APPENDIX CRR

Table of responses to Section 42 consultation held between 26 October 2020 and 14 December 2020, replies from the applicant and how the applicant has taken account of the issues raised in preparation of the final application and Environmental Statement.

PINS project reference: WS010005

Table ES2.2

Title
Entrance Widening

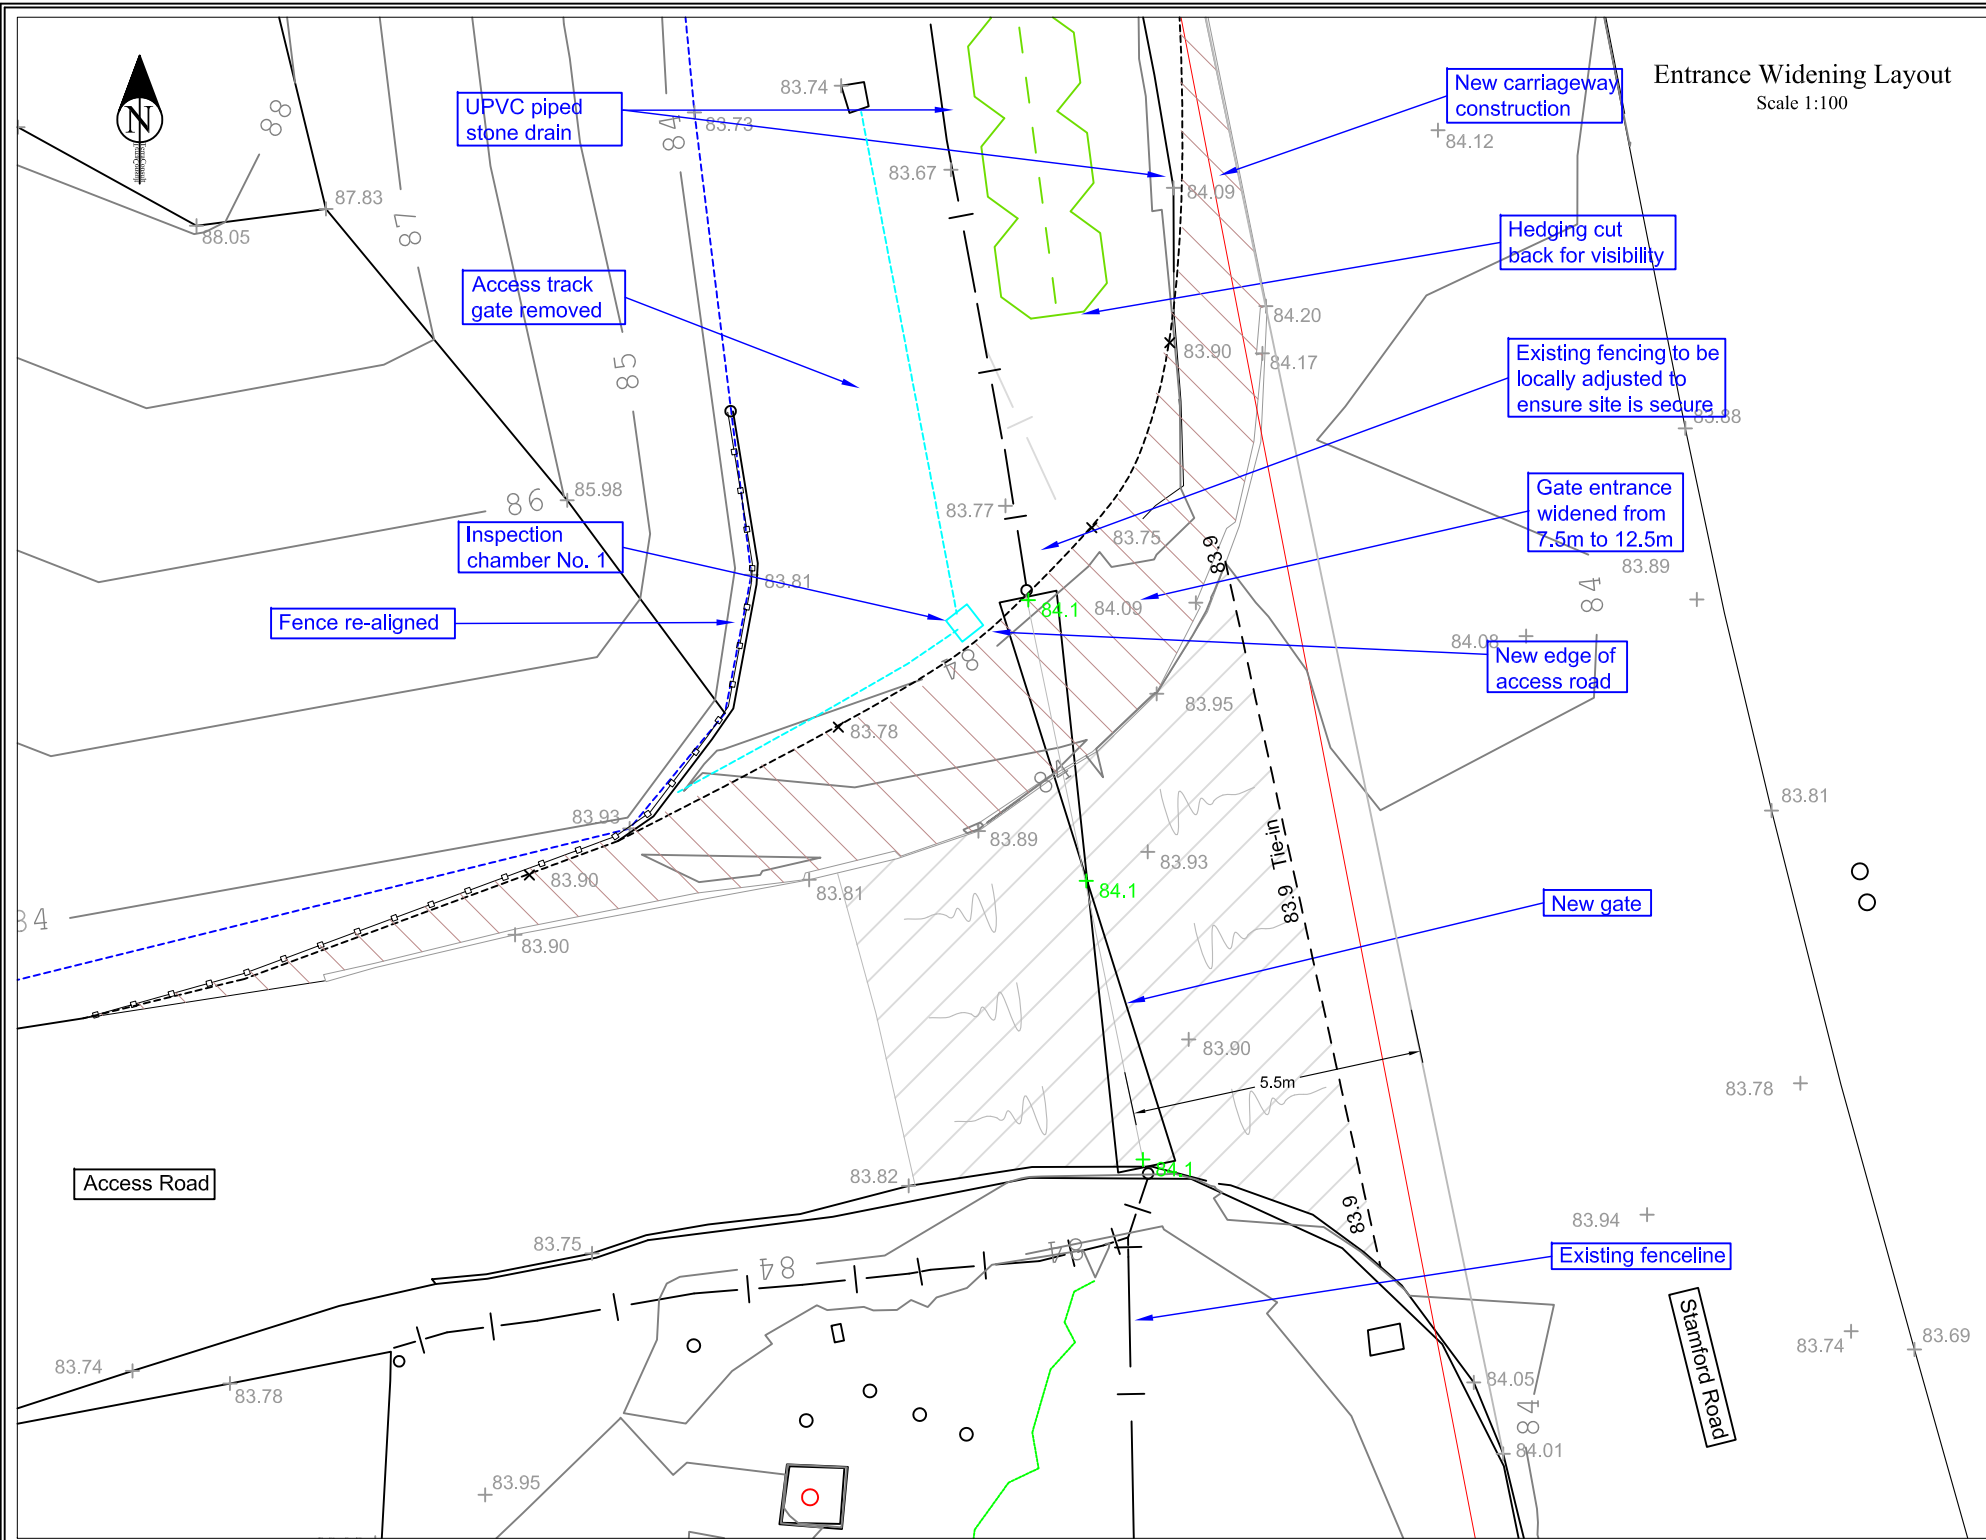
S42 consultee	Summary of the key comments on the PEIR.	Responses to the key comments and issues
	<p>The current site access arrangements appear sub-standard. We will require confirmation of access width and radii with visibility splays shown on a scaled drawing. Vehicle tracking of the largest vehicles to enter site will also be required</p> <p>Improvements may be required for the junction of Stamford Road with the A47 subject to trip distribution information being provided.</p> <p>A suitably worded condition covering collection vehicles using the site access to not travel to the South of the site access on Stamford Road towards the village of Kings Cliffe, unless they are delivering wastes collected locally will be required.</p>	<p>proposed that a similar requirement will be included in the draft DCO (PINS document reference 3.1) for the proposed development</p>
<p>East Northamptonshire District Council</p>	<p>The justification provided in the consultation documentation for the significantly increased land levels proposed by the 'domed' restored landform is noted, however further justification and explanation for the 'domed' restoration profile is required.</p> <p>An analysis should be undertaken to determine what trees and vegetation would be growing on the site in around 200 years time, taking account of climate change, to ensure the capping layer would be sufficient to withstand root penetration from these species.</p>	<p>A domed restoration profile is necessary for landfill sites which accept non-inert waste in order to maximise the runoff of rainfall. The final profile of the waste and capping layer is designed to form a stable slope which will encourage shedding of rainfall to minimise infiltration and as a consequence to minimise the generation of leachate. Leachate is the contaminated liquid formed when water infiltrates into the waste and which is collected in the base of the site from where it is collected and managed. Further detail on the design of the landfill site including justification for the restoration profile is provided in Section 5 of this ES.</p> <p>The restoration scheme for the site includes the planting of trees on the restored site. The final details including the types of trees which will be planted have been discussed and agreed with Natural England. Detailed discussions have taken place with Natural England as well as North Northamptonshire Council, Forestry England and the Wildlife Trust in order to agree the restoration planting scheme which included discussions on tree species. Actions are also</p>
